Recommendation Report for Planning Permission for Works or Extension to a Dwelling

REF NO: AL/31/19/HH

LOCATION: 16 Church Road
Aldingbourne
PO20 3TT

PROPOSAL: Single storey rear extension and replacing front windows. This application affects the character and appearance of Church Road Conservation Area.

Proposed Ground Floor
1 : 50

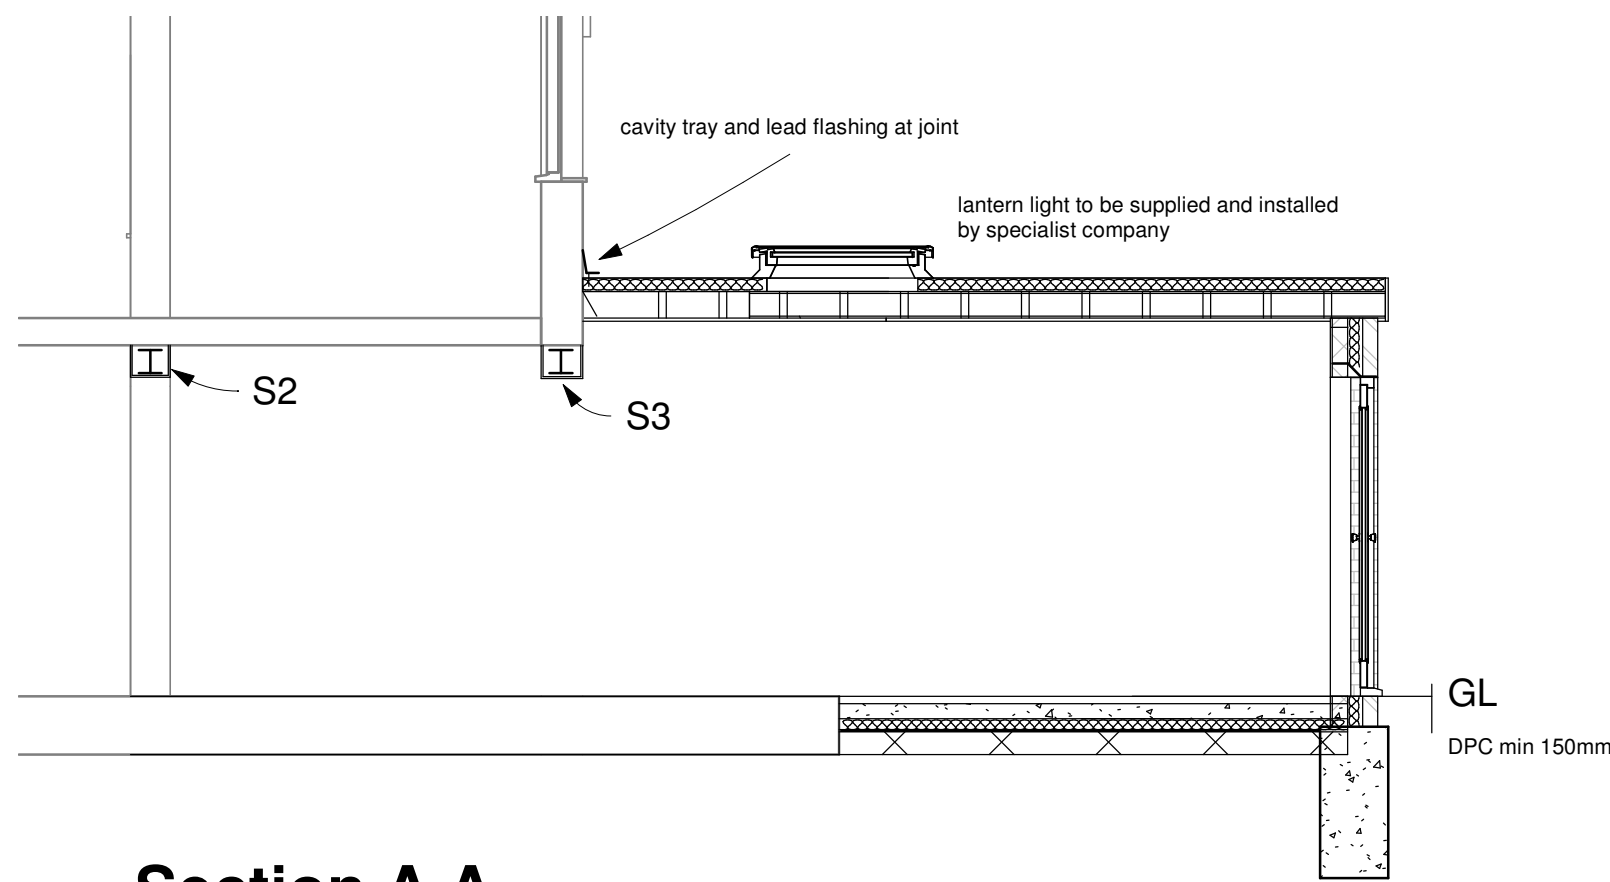
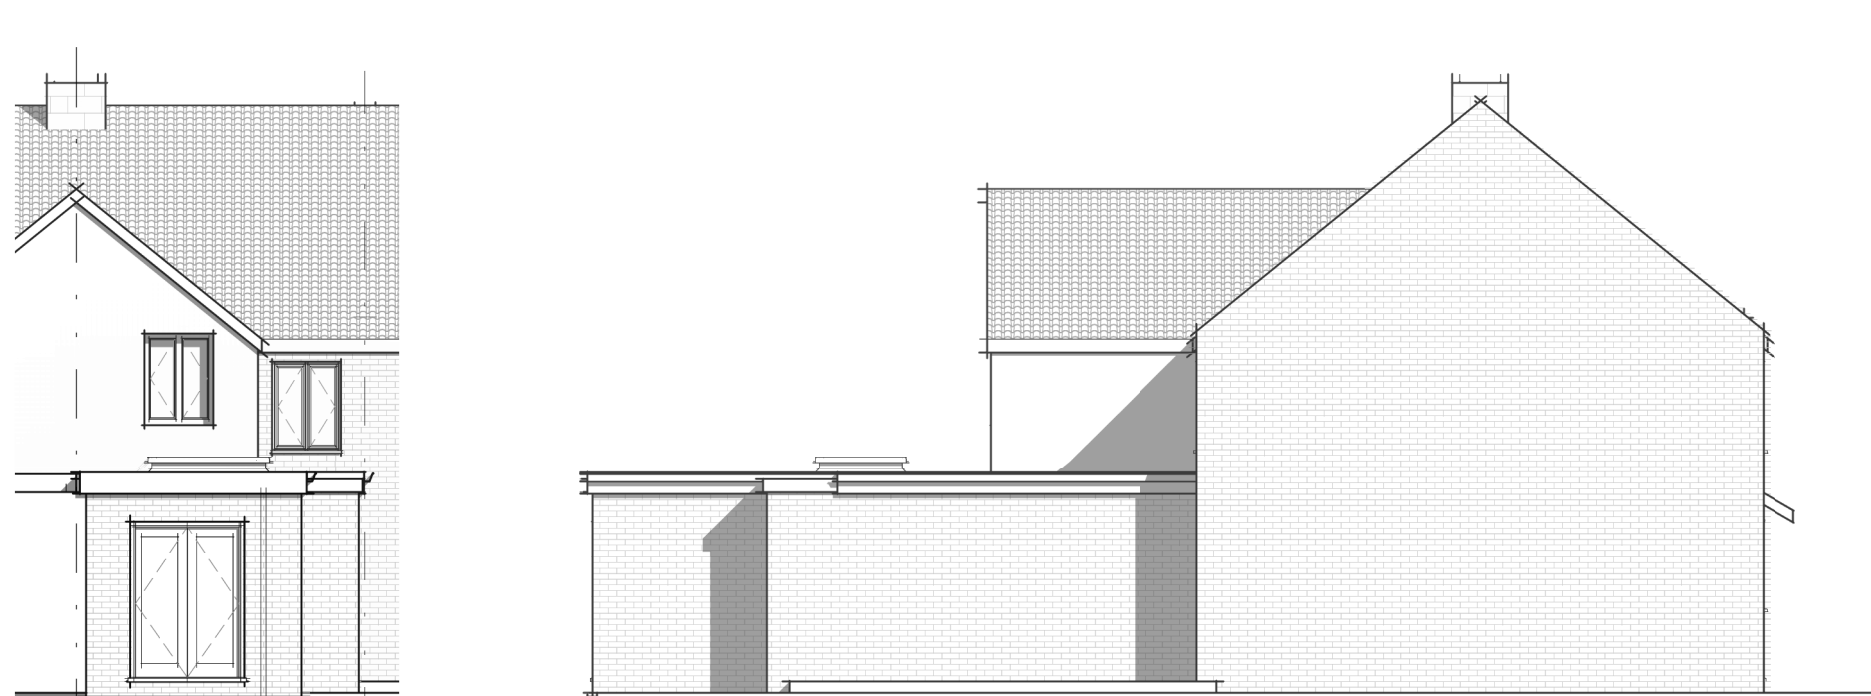
An existing sloped roof rear addition and conservatory will be removed and replaced with a flat roof extension. This will run along the southern boundary. The width reduces slightly to retain around 0.85m to the boundary. To the rear elevation the depth will increase an overall 1.5m. The extension will have a height of 3m with a maximum of 3.15 with a roof lantern. A door will be sited to the rear views are not considered to increase from that which is already possible.

The neighbouring property at No.14 has a rear extension also constructed in similar design and size to that which is proposed and therefore the development is not considered to appear adversely overbearing or overshadowing upon this elevation.

Whilst the development is situated close to the boundary at No.18 there is fencing in place and with the proposal at a modest height again it is not considered to result in significant overbearing impacts. The extension would intersect a 45 degree angle from part of the rear of the neighbouring property however the existing addition and conservatory would have intersected it also and the increase in depth is not considered such that a refusal is justified.

Proposed Front
1 : 100

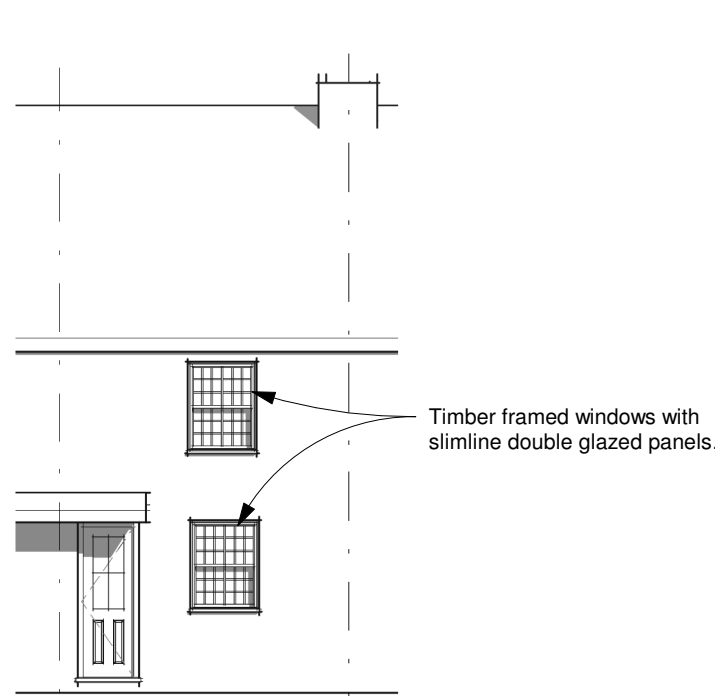
The extension is located to the rear of the property and is therefore not visible from the street scene. The proposal seeks to replace windows to the front elevation. These will be timber framed with slimline double glazed panels. As a result of the materials proposed they are considered to retain the existing appearance and appear sympathetic to the design of the existing dwelling. The neighbouring properties have been constructed identical in appearance and therefore the materials proposed also ensure the development is in keeping with the surrounding area.

The concept of a rear, single storey extension is acceptable as it will not be seen from the public domain. With regards to the replacement windows, the design has been amended so that the replacement windows are now to be timber framed with slimline double glazed panels. Such a concept is acceptable, subject to the replacement windows closely reflecting existing ones in terms of design and appearance. The application is considered to not cause harm to the significance of the heritage asset or setting.

- 3 Before the windows are inserted details of thee windows (e.g. manufacturers catalogue or scaled drawings) shall be submitted to and approved in writing by the Local Planning Authority.
